Our ref: PR145916

Date: 10 June 2020

New Catherine Field Primary School (SSD-9477): Response to Request for Additional Information (RFI)

Figure 1: Construction Vehicle Routes

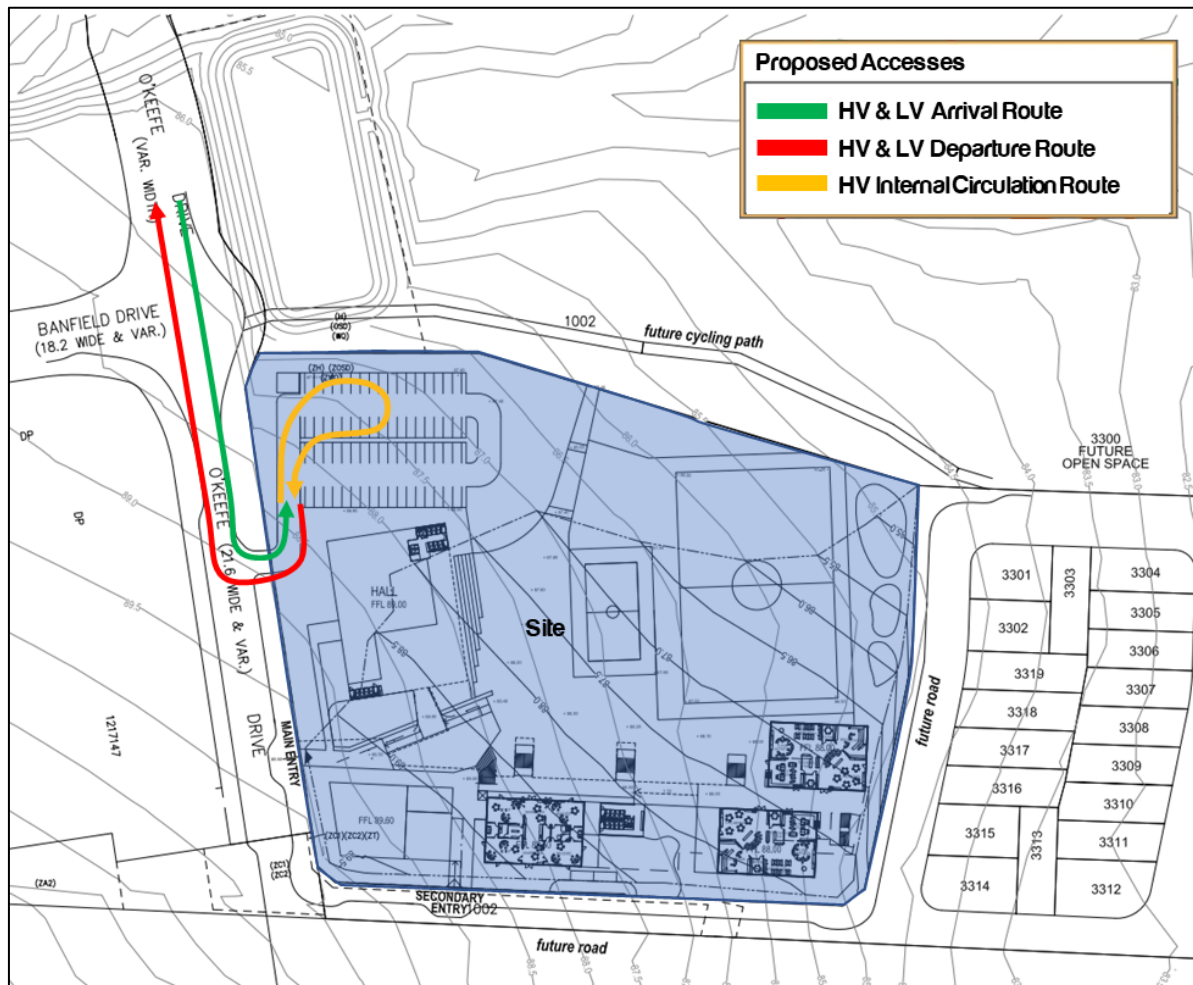
Further details regarding heavy construction vehicle access and egress as well as construction workers vehicle parking should be

outlined in a revised Construction Management Plan. Figure 2 in the existing plan is inadequate.

The CMP has been amended accordingly.

Figure 2: Indicative Pedestrian Crossing Locations

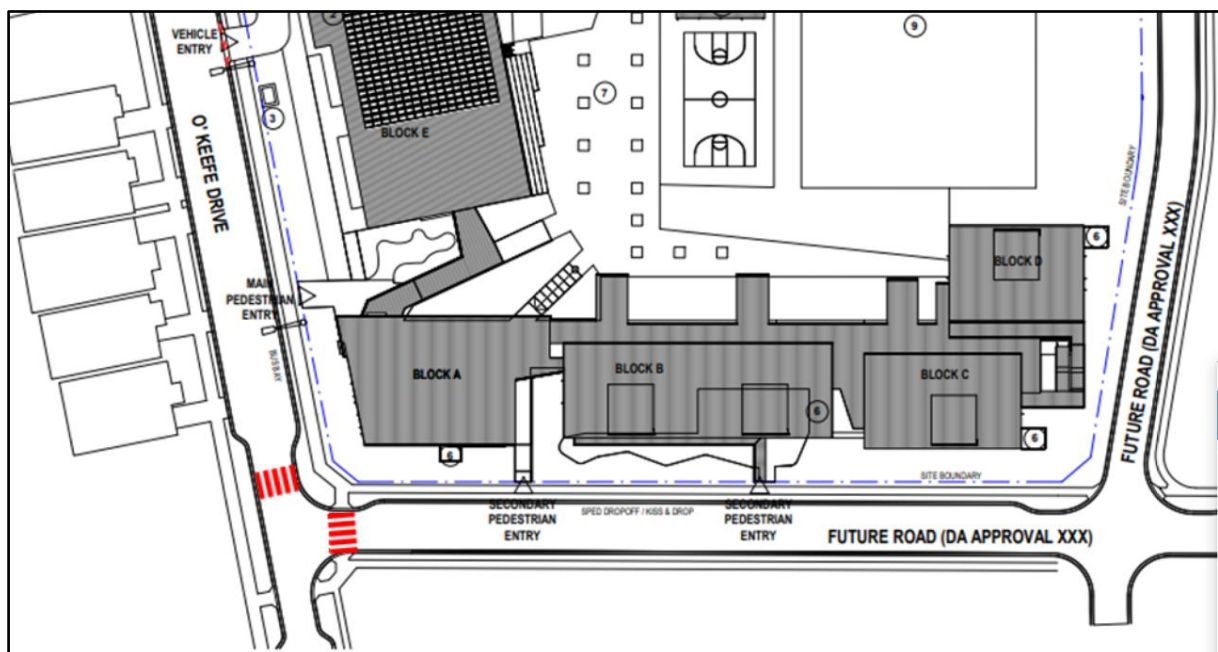
3. Regarding pedestrian crossings – Council agrees that the TfNSW warrants technically need to be met however Council will seek to propose the implementation and present the pedestrian crossing to Local Traffic Committee. It may be a possibility that the design be requested to be amended to a pedestrian crossing however Council would prefer initial plans to present pedestrian	We acknowledge safety of school children is key consideration when planning for a new school. Prior to the school's occupation, SINSW will work closely with TfNSW to determine and confirm school crossings and pedestrian crossing locations and requirements. School crossings generally operate before, during and after school hours and display red flags

crossings and will base its argument on other schools within the LGA. Although mid-block crossings are generally preferred it would not be practical on O'Keefe Drive due to the location of existing driveways. However it may be achieved on the future road 610 – to minimise potential impact on traffic flow better service people utilising the secondary site entry.	containing the words 'childrens crossing.' The crossings alert drivers to slow down and halt before a stop sign when a pedestrian is on the crossing or waiting at the crossing. Drivers cannot proceed until the pedestrian is off the road. Pedestrian crossings are special markings on the road that show where pedestrians have special rights at all times. The crossings allow people to cross the road safely and are usually marked by white stripes on the road. Drivers must give way to pedestrians at all times. As already acknowledged in the RtS, further investigation by the relevant authorities will be required associated with the new school, regarding crossings. TfNSW have established criteria required to issue pedestrian crossing warrants that ensure they are safe and effective for all road users. A warrant provides assurance to the public and the relevant authorities that the proposed traffic and transport facilities have been extensively investigated and considered by the relevant local Council Traffic Committee. SINSW will seek relevant warrants without the usual operational data. This early application should assist parents and students to better plan their trips to the new school. If the proposed crossings meet the requirements of a pedestrian crossing warrant, it will also assist in encouraging more active transport options to reduce the number of cars on local roads and improve community health and wellbeing.
